**Arrangements for Handling Heritage Applications Direction 2021 & Planning
(Listed Buildings and Conservation Areas) Regulations 1990**

**George Hotel, St George's Square, Huddersfield, HD1 1JA
Application No. 2026/65/91370/W**

Historic England consider that the proposed temporary stair would cause a less than substantial amount of harm to the significance of The George Hotel, a nationally significant Grade II* listed building.

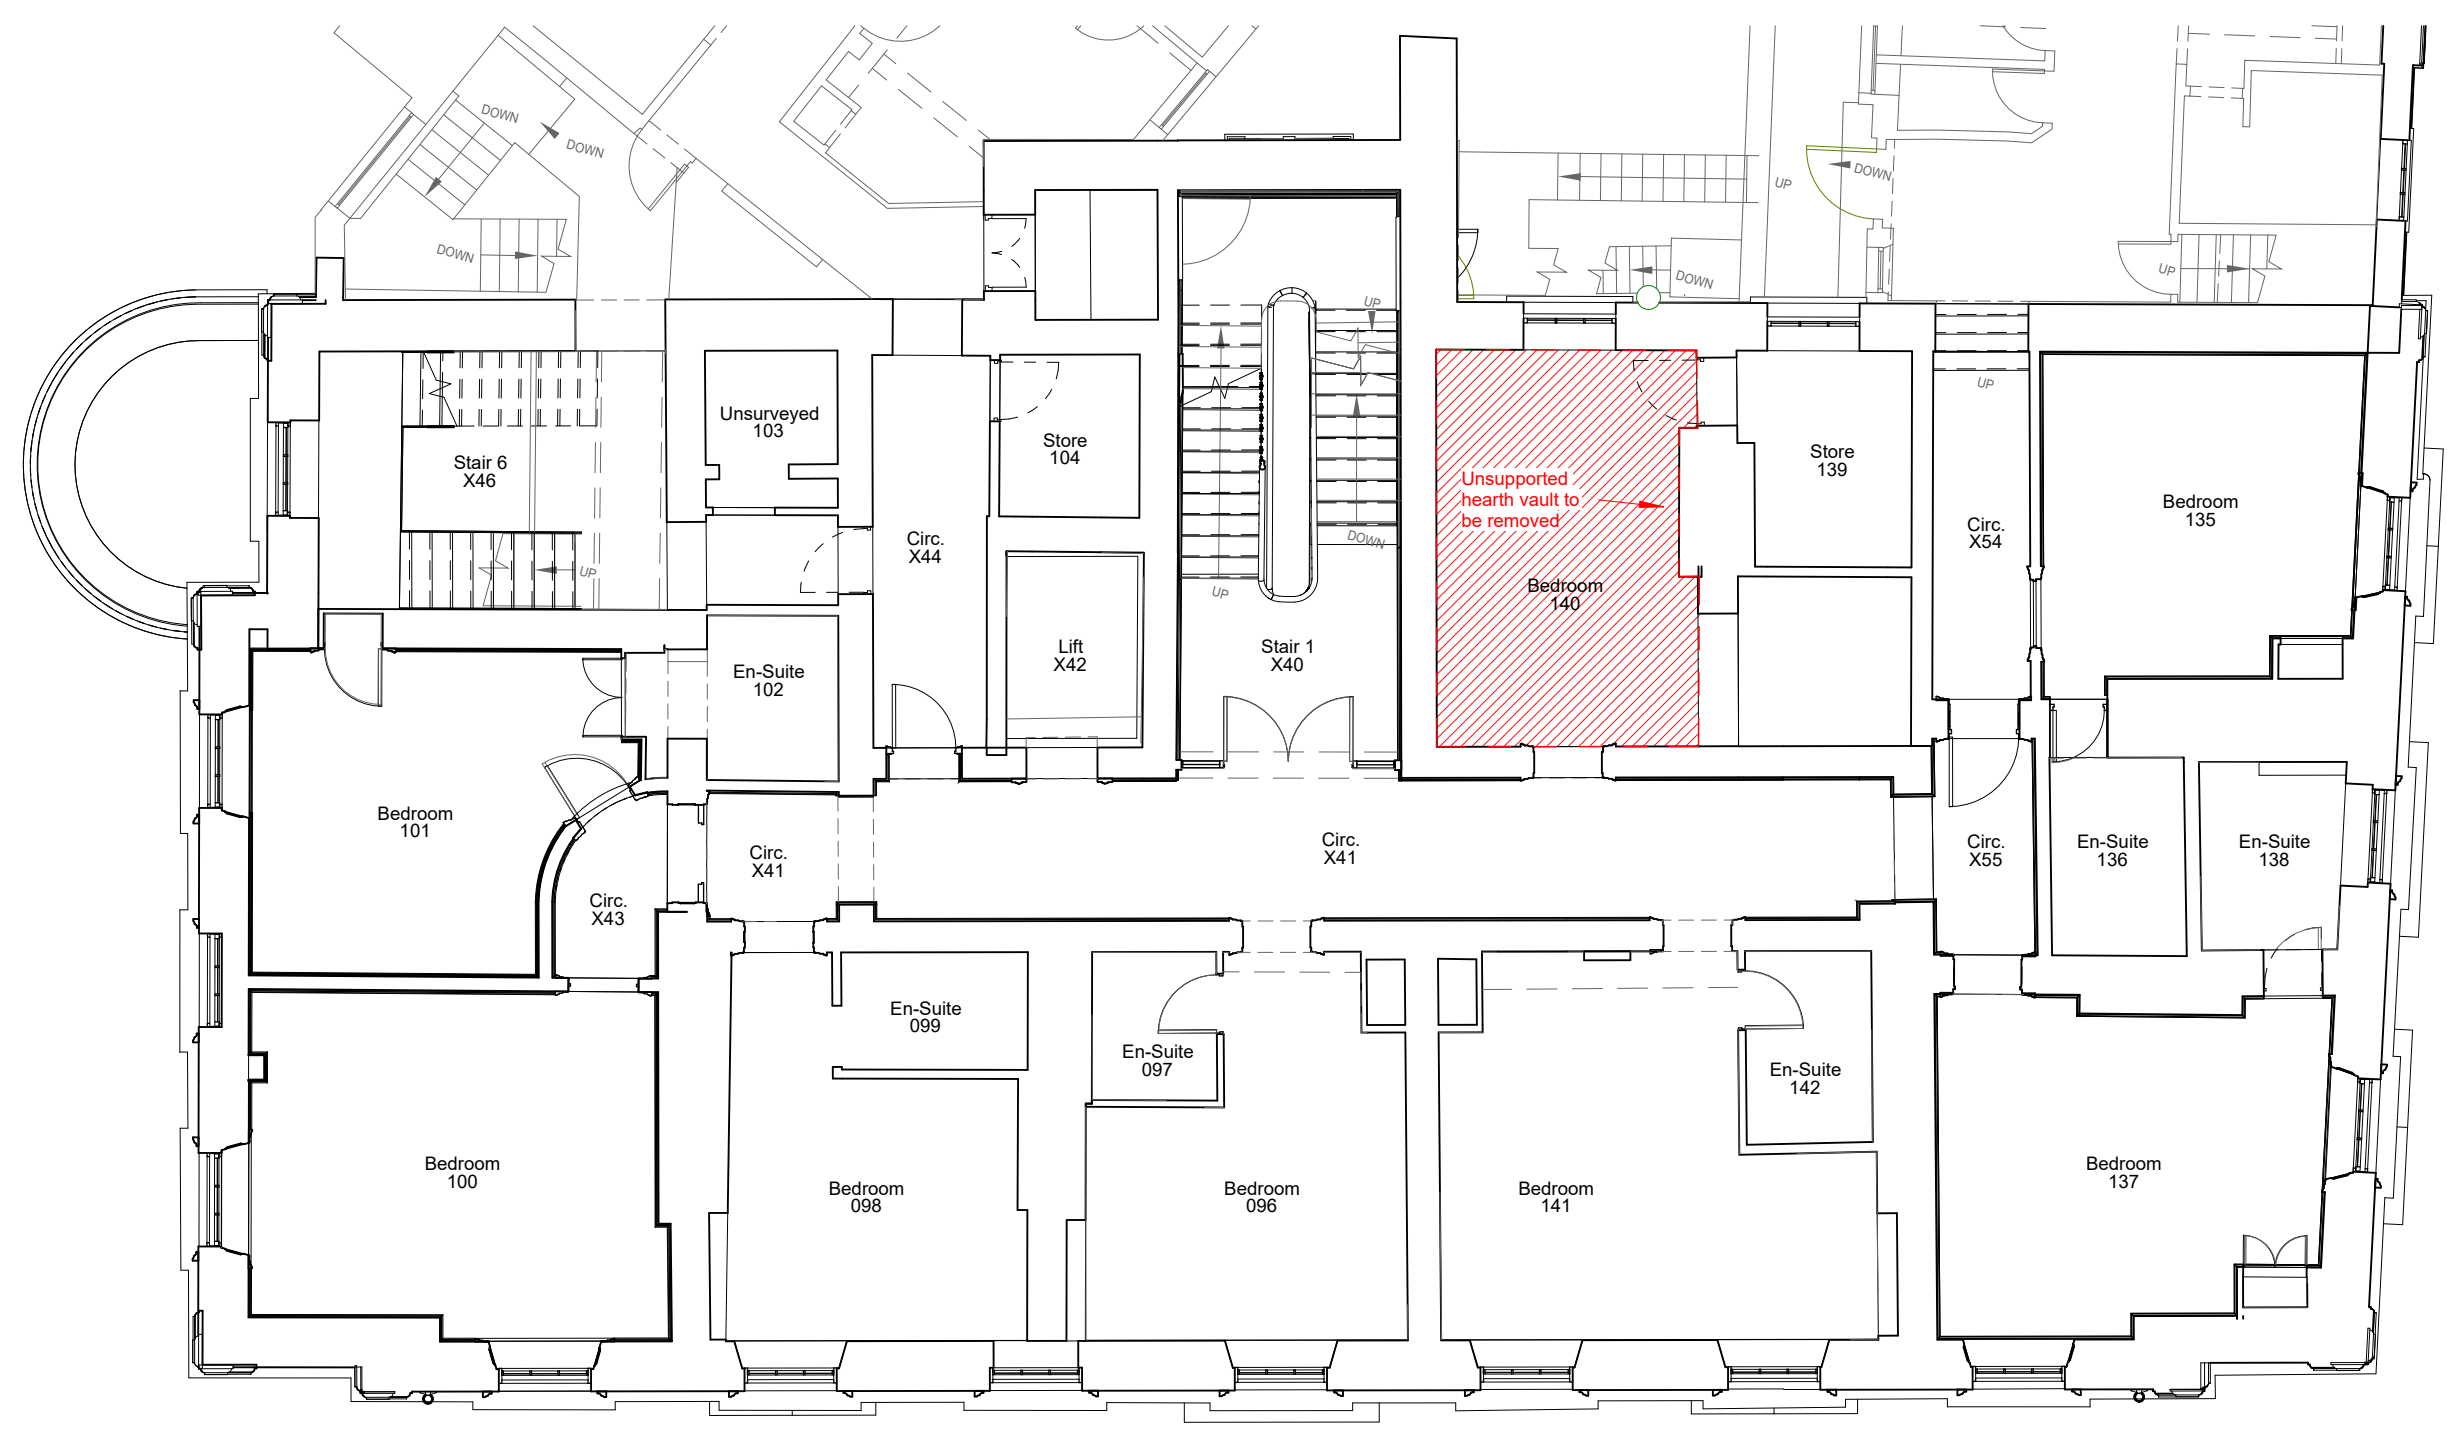
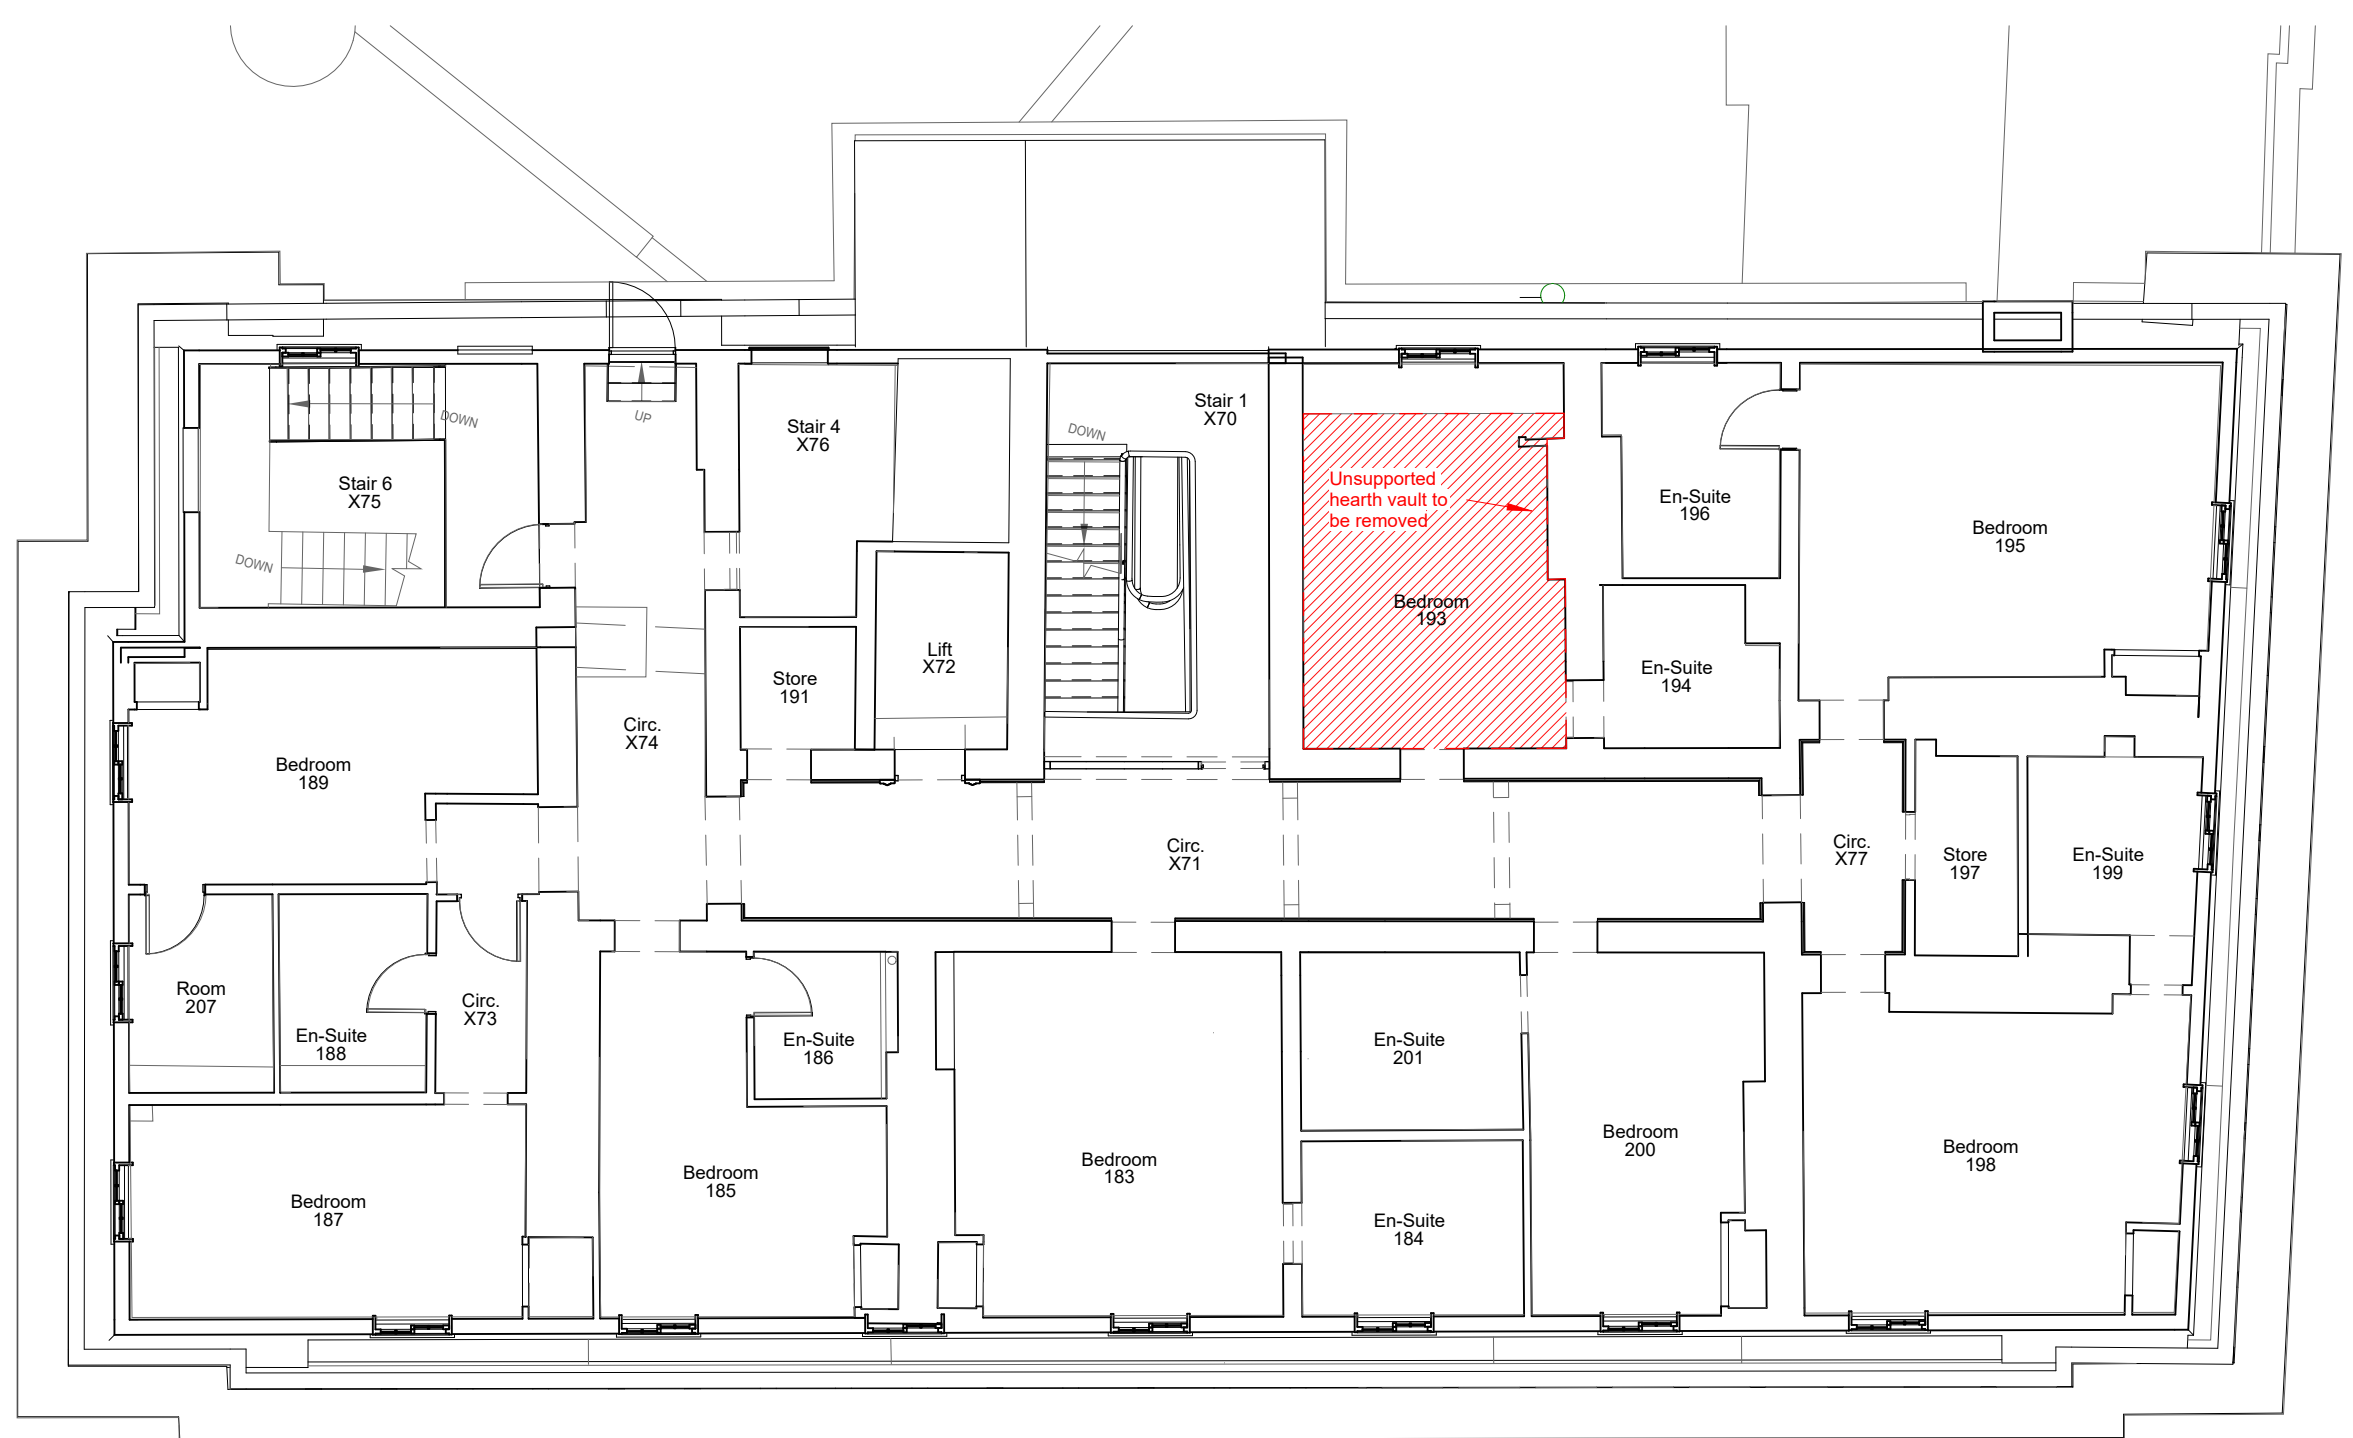
The proposed temporary service stair would lead to the physical harm to historic fabric across all floors.

This harm is isolated to one room in which a section of floor boards and joists would be cut out. This is considered to cause a less than substantial amount of harm the significance of The George Hotel through the loss of historic fabric.

It is proposed to reinstate the floors which will minimally mitigate the identified harm above.
